Gravesham Borough Council

Lower Thames Crossing

Deadline 7 submission

*Local Landscape Character Area boundaries of the Kent Downs AONB LCA, West Kent Downs, Sub-areas Cobham and Shorne*

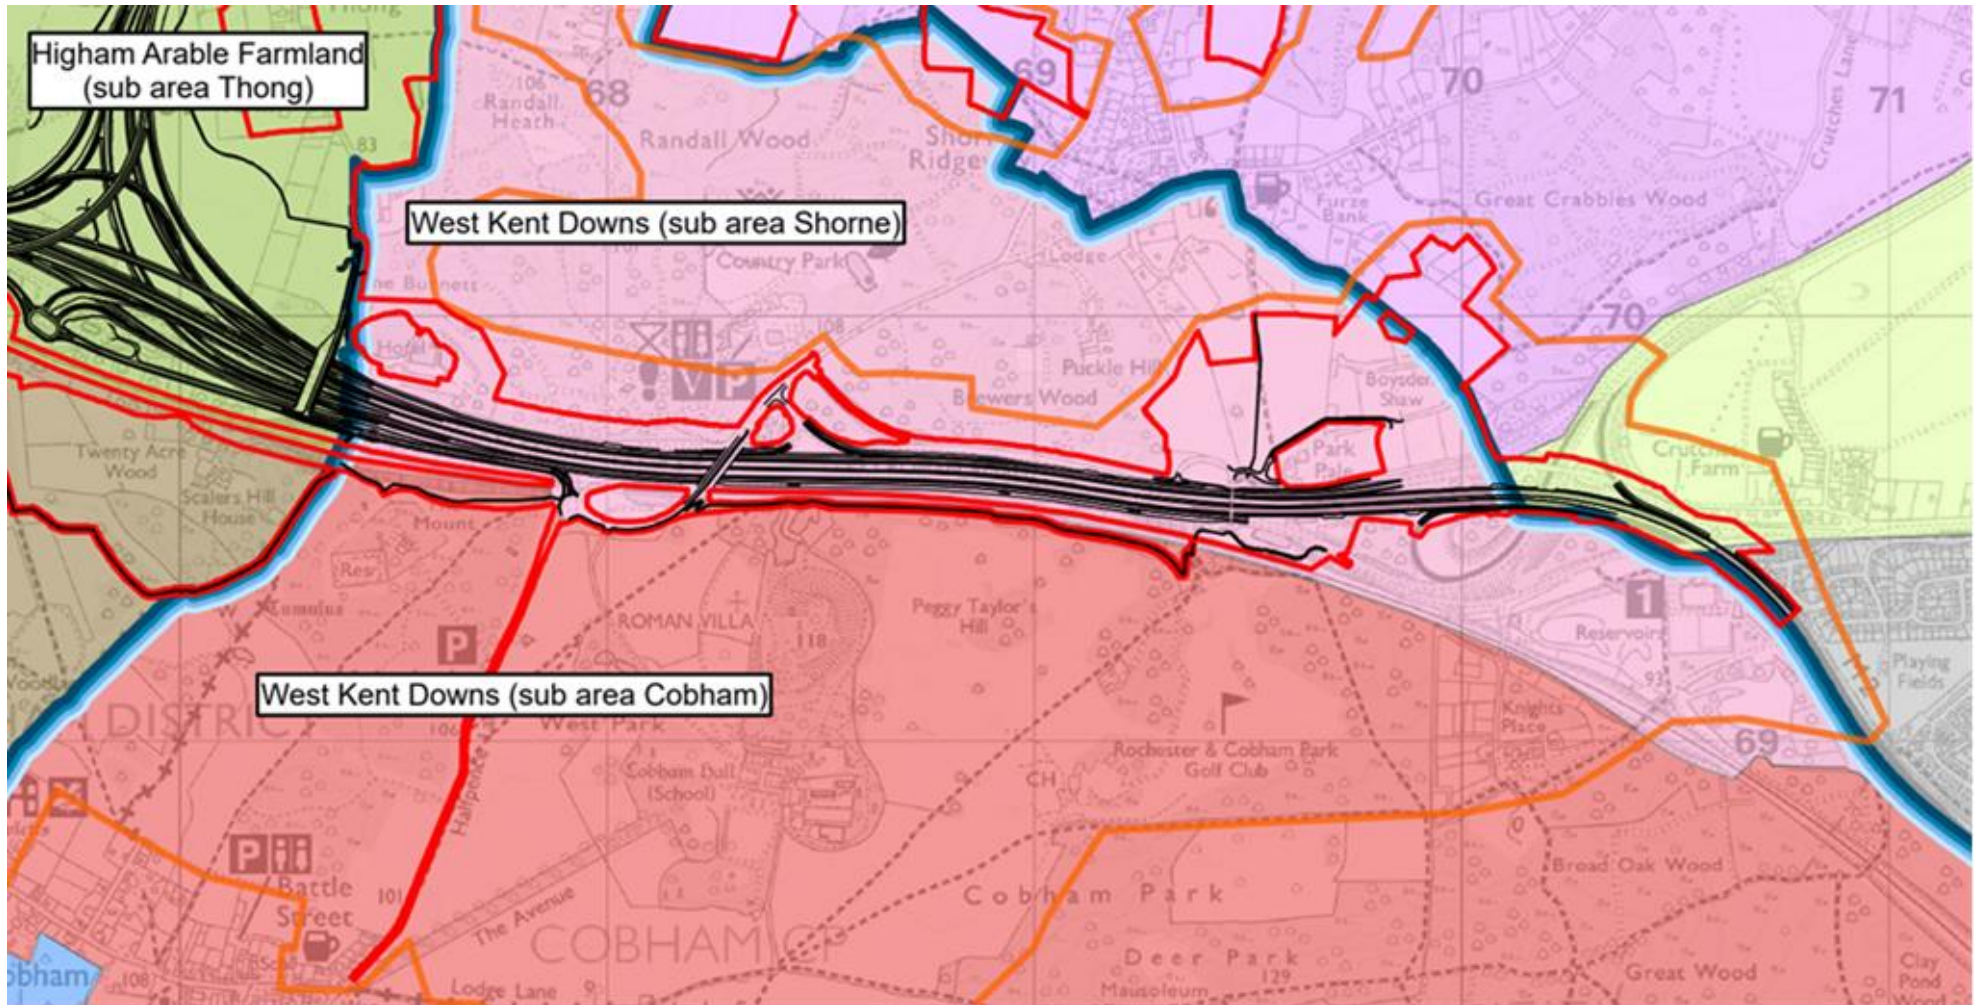
Whilst the Council notes the Applicant's position that an assessment of the susceptibility of a landscape character area to accommodate change will be informed, to some extent, by the nature of the proposal that is being considered (and so to that extent is not purely a baseline assessment) the Council remains unconvinced that the relatively modest changes to the proposal between 2020 and 2022 are sufficient in themselves to adequately explain the regrading of the Cobham LLCA's susceptibility such that the sensitivity of that area is then downgraded from 'very high' to 'high'.
